**FIVE ESTUARIES OFFSHORE WIND FARM DEVELOPMENT CONSENT ORDER**

**PINS REFERENCE EN010115**

**DEADLINE 7: PORT OF LONDON  
AUTHORITY'S COMMENTS ON SUBMISSIONS  
RECEIVED AT DEADLINE 6**

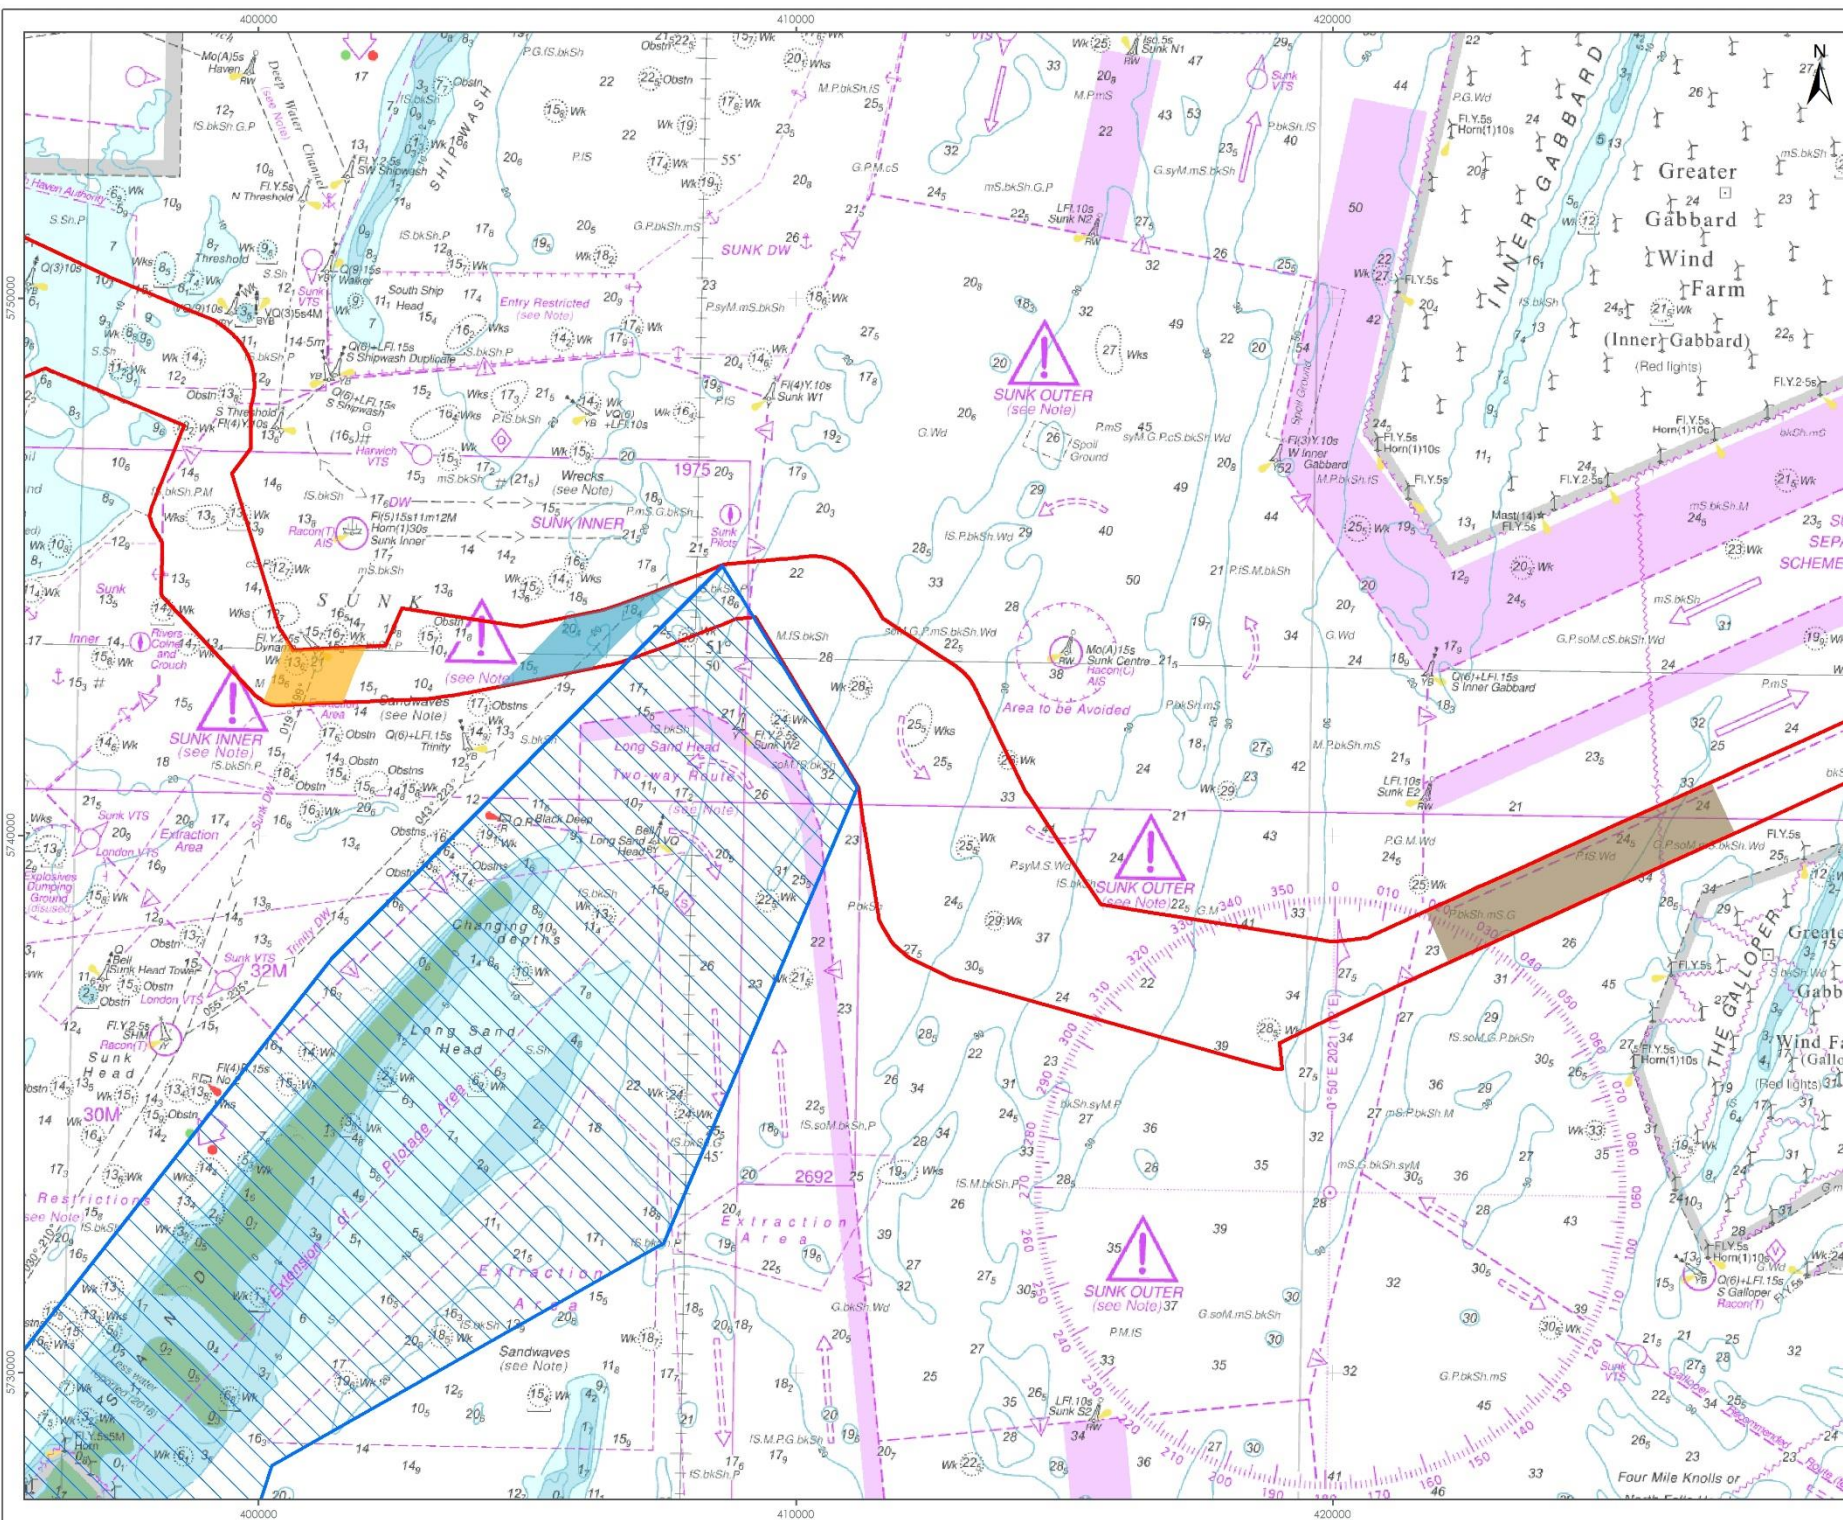
5.2 Whilst some clarification has been provided in relation to the pilot boarding area it does not appear to rule out disposal of material in this area – stating at paragraph 3.5.2 that it will avoid, where possible, the disposal of material. This does not provide the certainty required in relation to this very important area for navigation. The reference to not reducing navigable depth within the pilot boarding area has not been amended so it is not clear whether this is from current depths or whether up to 5% of navigable depth could be lost
